Ribble Valley Borough Council  
Housing & Development Control

Application no: **3/2021/0771**

Address: **Tan Yard Farm Ribchester Road Hothersall PR3 3YA**

Proposal: **Prior notification of the proposed change of use of two traditional stone barns to form three new dwelling houses with associated building works including the insertion of new door and window openings to achieve natural light in all habitable rooms.**

PROPOSED SITE PLAN

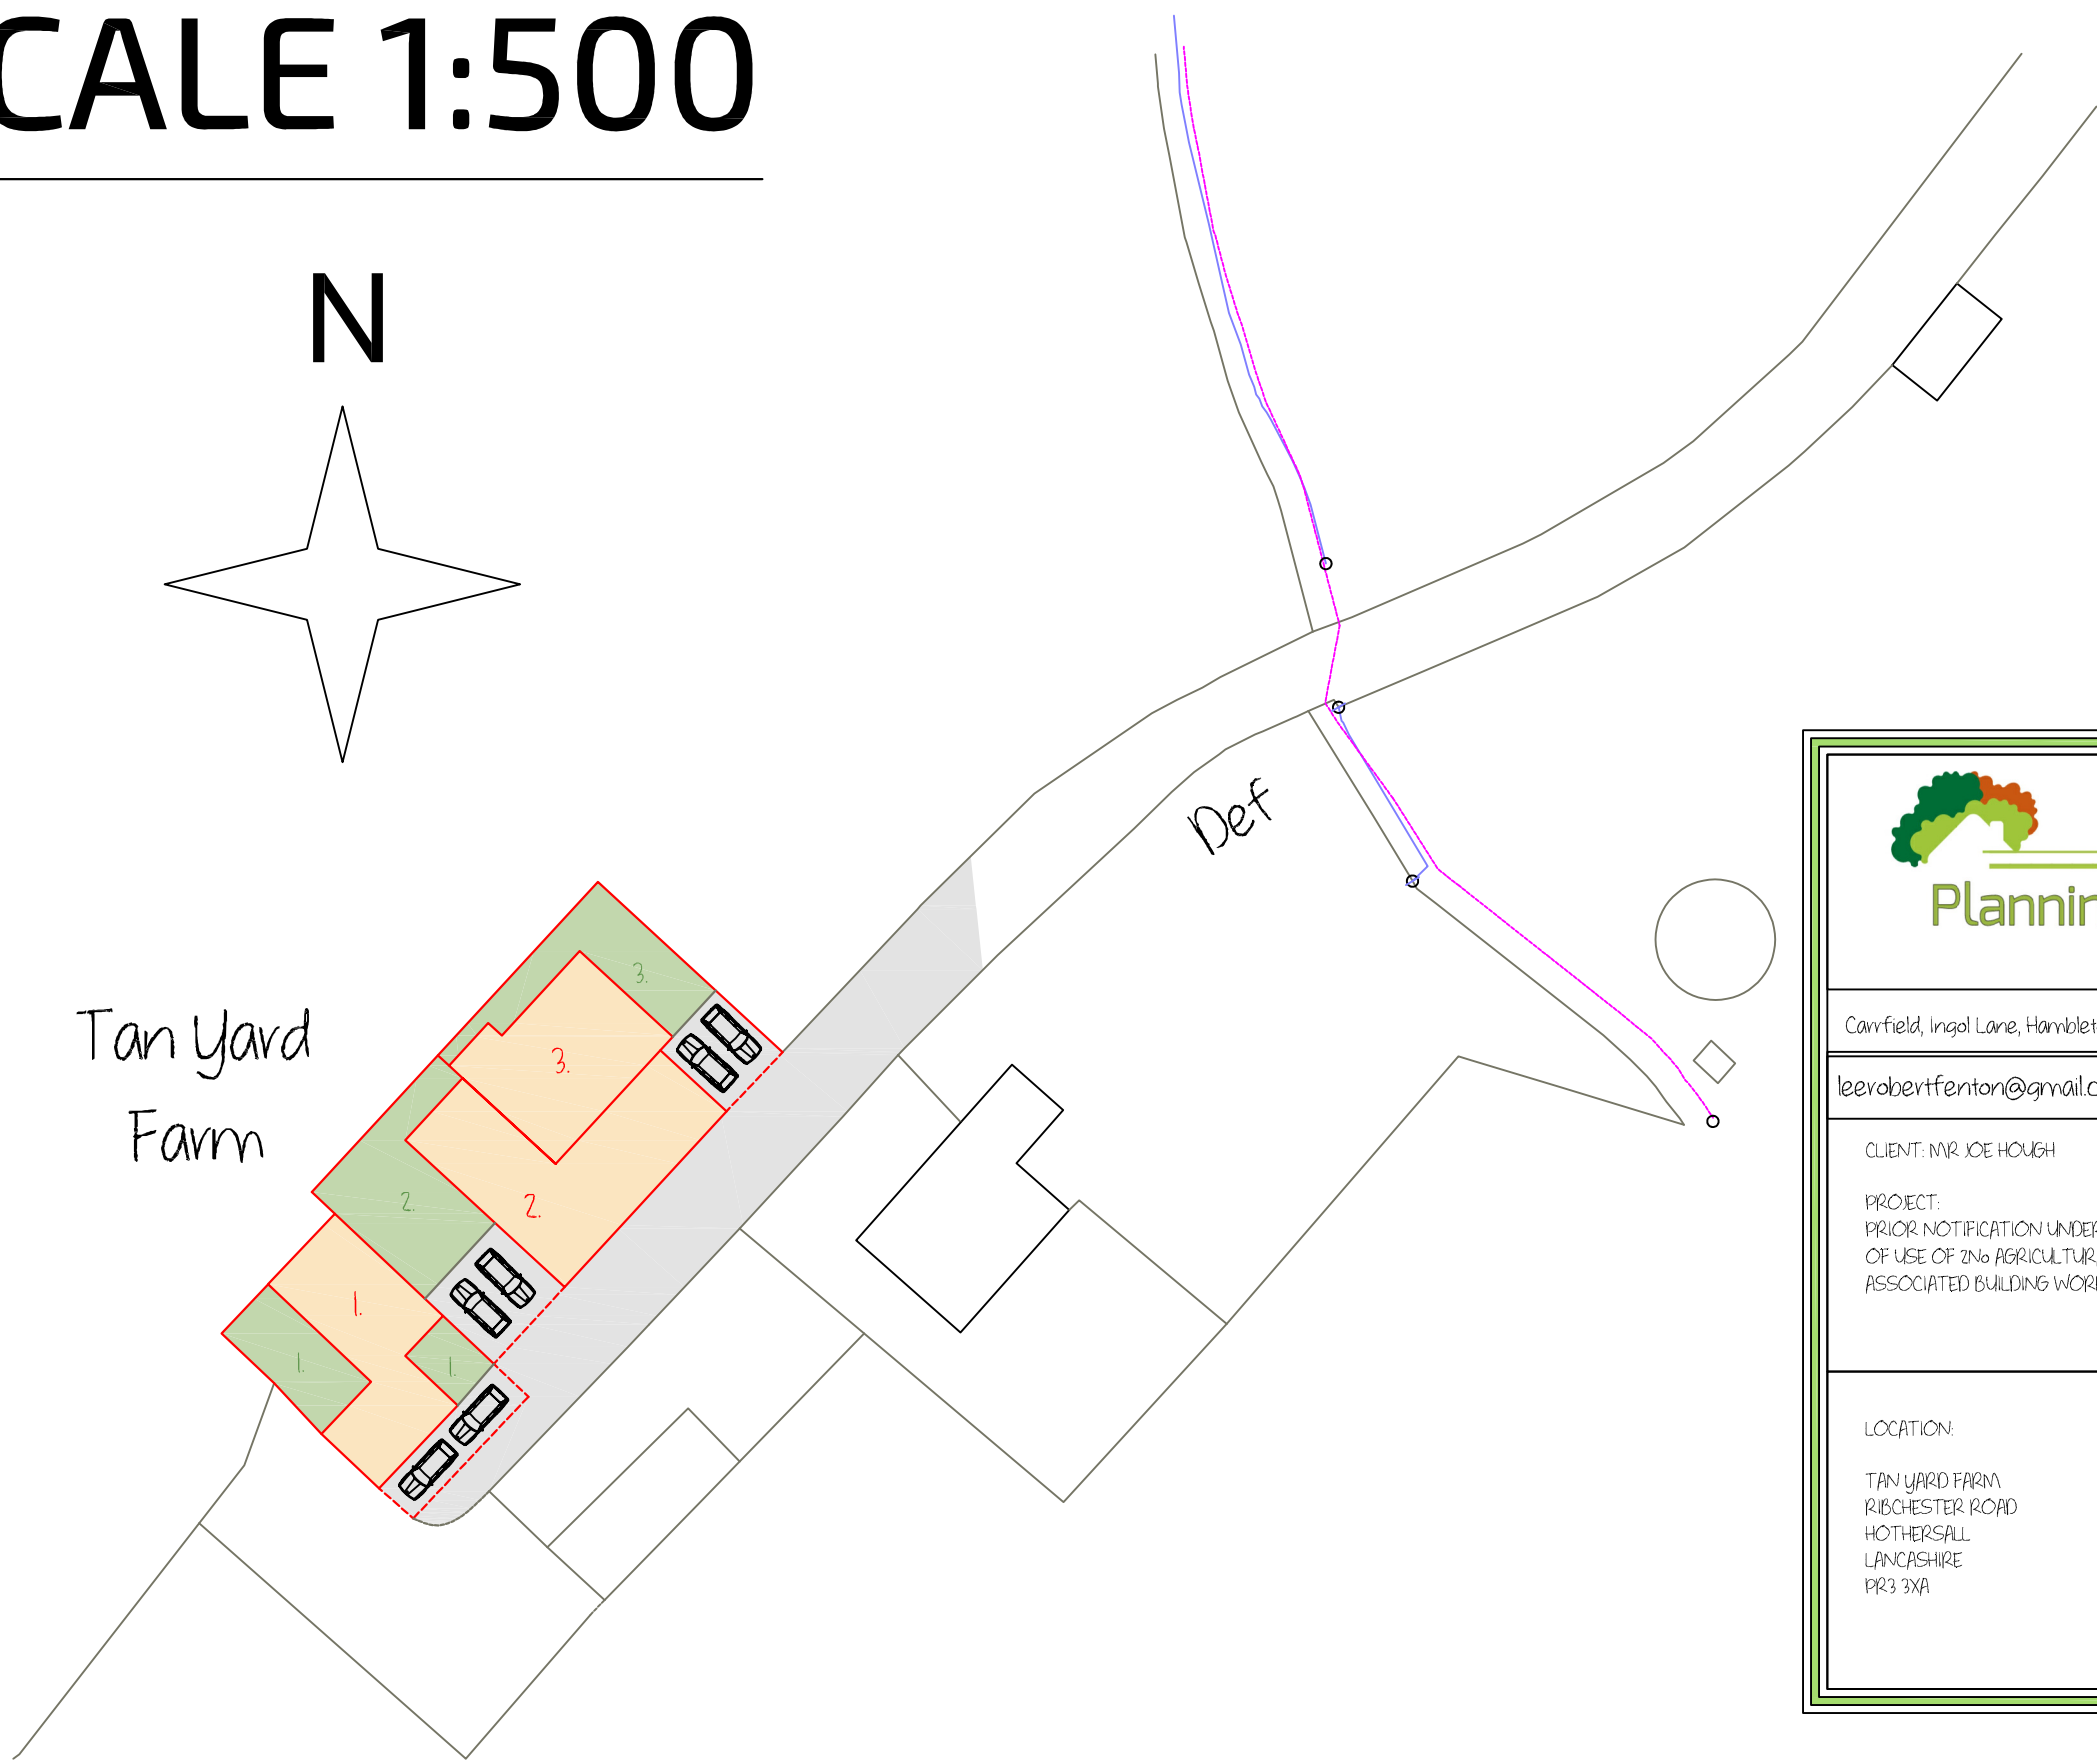
The LHA have reviewed Lee Fenton drawing number LF/JH/3603 and understands that 2 car parking spaces per dwelling will be provided at the site. This complies with the parking guidance as defined in the Joint Lancashire Structure Plan.

However, the LHA have reviewed the drawing and have concerns regarding the parking spaces provided for Plot 1. This is because, firstly, the LHA are unsure where vehicles parked in these spaces will be able to turn around and leave the site in a forward gear. This is because the 2 spaces are provided in a parallel parking formation. Therefore, the LHA have concerns where these vehicles can turn around, especially when the driveways of the neighbouring dwellings have vehicles parked in them. This could lead to vehicles parked in the spaces in Plot 1 to reverse a significant distance down the track towards the public highway to find a turning area.

Not only this but the dimensions of the parallel space which will provide 2 spaces do not comply with the LHAs guidance. This is because the length of the space is only 11.3m, while the guidance requires the length to be 12m when the space is providing 2 spaces. Therefore, there is a shortfall in 0.7m. The shortfall in the space could lead to one of the parked vehicles overlapping the designated parking area for Plot 1,

meaning that the space will obstruct the driveway for Plot 2. This could cause vehicles exiting the driveway of Plot 2 to be unable to exit until the vehicle moves.

However, the LHA do advise that these issues are resolved and that the parking spaces for Plot 1 are relocated and provided in a more traditional manner. One solution is to relocate the spaces adjacent to Plot 3.

The LHA have reviewed the supporting documents and are requesting that a more detailed access drawing is submitted showing the width of the access.

The LHA remind the Applicant that an access serving 3 dwellings is required to be 4.25m wide for a total distance of 5m from the highway boundary.

The LHA also require a revised drawing to show that the site can provide visibility splays of 2.4m x 65m in both directions.

Furthermore, the LHA would also advise that the access track has at least one passing bay so that two-way movements can occur at the site. The LHA advise the Applicant that the dimensions of the passing bay should be 2m wide x 5.5m in length.
